Our Ref: LU/404/17/PL

**Town & Country Planning Act 1990 (as amended)
Town and Country Planning (Development Management Procedure) (England) Order 2015
Application for Planning Permission**

Development Removal & replacement of single storey outbuilding in retail use, removal of substandard first floor extension to flat No. 1 & structural repairs to existing main pitched roof.

Location 2-6 Beach Road Littlehampton

WEST [BACK] ELEVATION

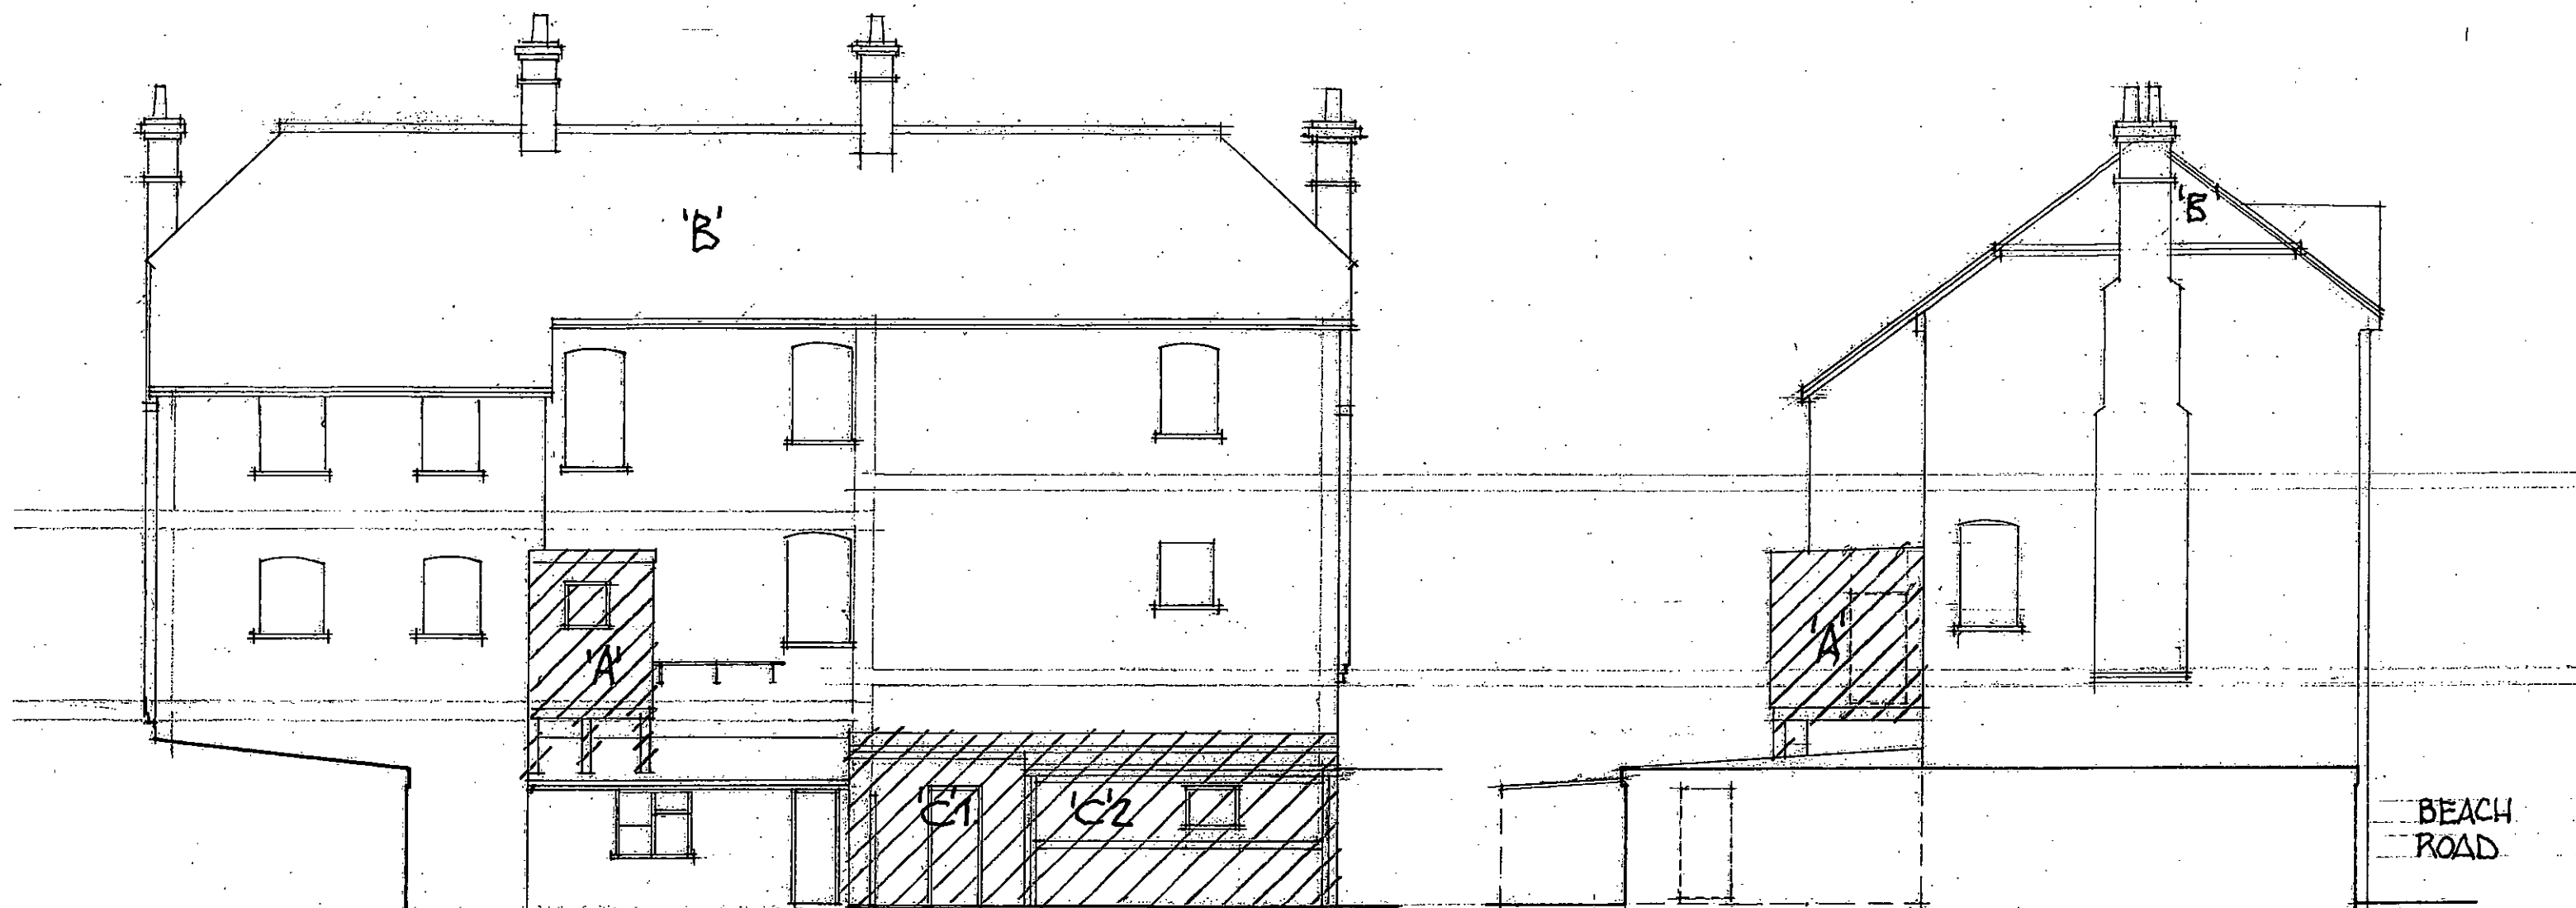
The proposed ground floor plan and west elevation do not accord. Please amend accordingly.

1:1250 LOCATION PLAN

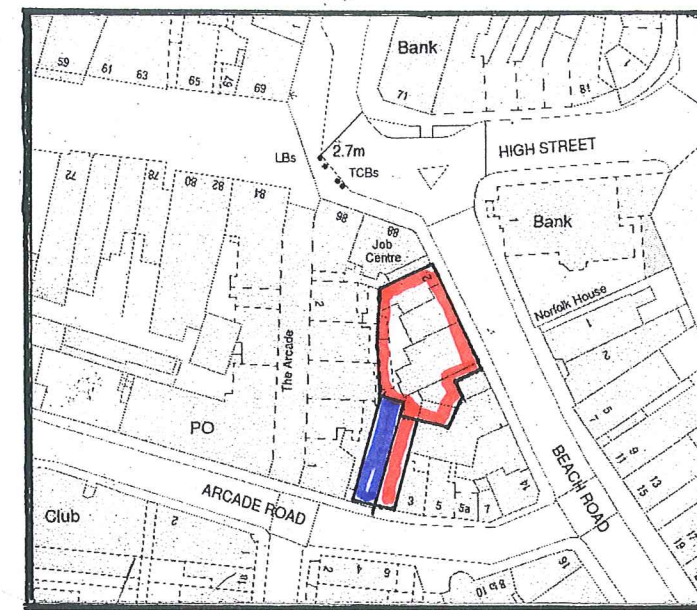
Location Plan Amend

Please submit 1 electronic or 3 paper copies of a location plan at a scale of 1:1250 or 1:2500 for rural areas. Further details of what must be included on the plan can be found in the National Validation Requirements. Please provide a North point.

1:500 SITE PLAN

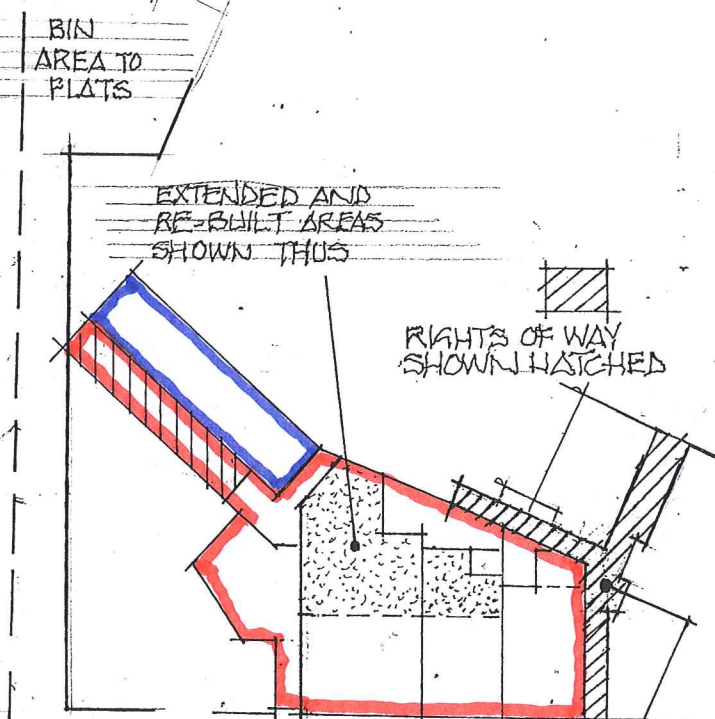
Block Plan Amend

Please submit 1 electronic or 3 paper copies of a block/site plan at a scale of 1:500 or 1:200. Further details of what must be included on the plan can be found in the National Validation Requirements. Please provide a North point and highlight/hatch the proposed extension.
